## PLANNING CONSULTATION RESPONSE

<b>Application No</b>	2025/0717
<b>Proposal</b>	Erection of 1.8m boundary wall (retrospective)
<b>Address</b>	2 Shire Oak Drive, Elsecar, Barnsley, S74 8HU
<b>Date of Consultation Reply</b>	10/03/26
<b>Consultee</b>	Highways DC

Dwg No
03

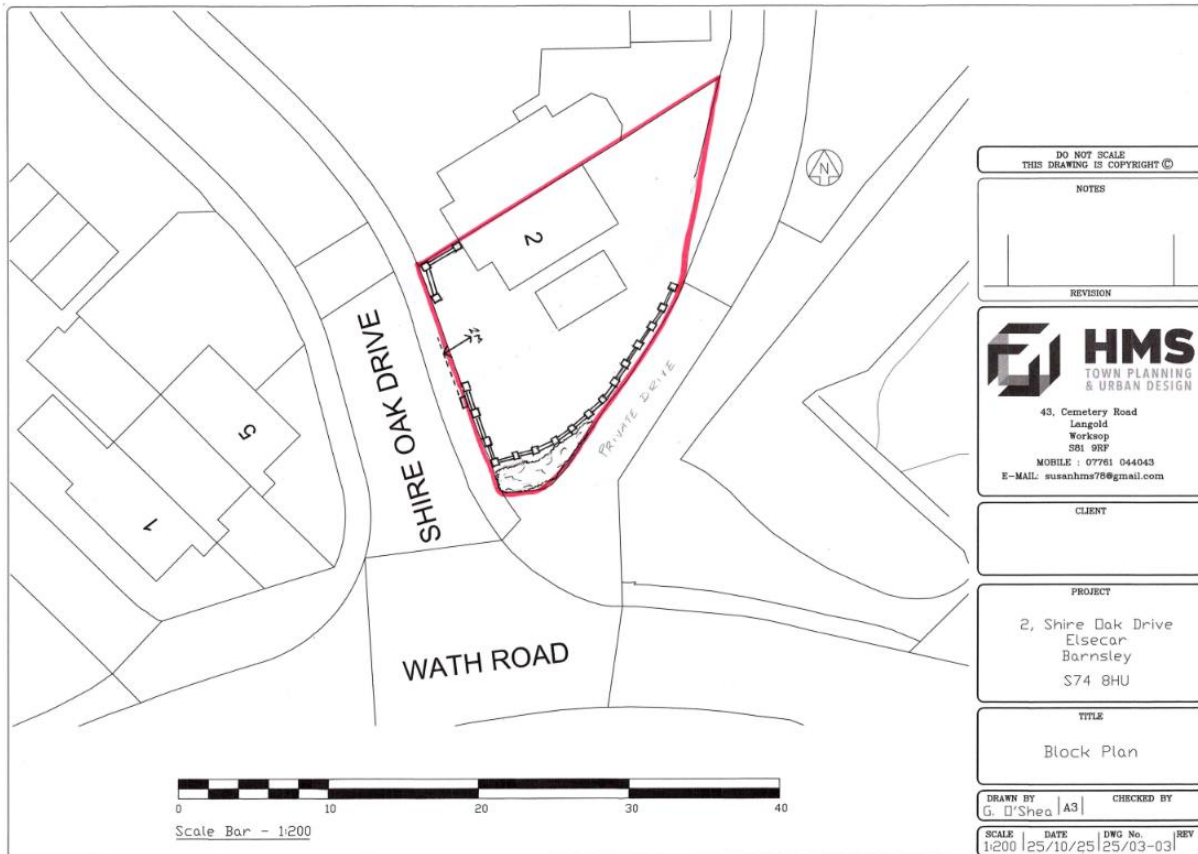
Previous comments were provided in October 2025 and January 2026 that requested pedestrian intervisibility splays on 2.0m x 2.0m be demonstrated on a plan.

These have now been shown satisfactorily on drawing no. 25/03-03 rev A and the scheme is therefore acceptable from the perspective of highway development control.
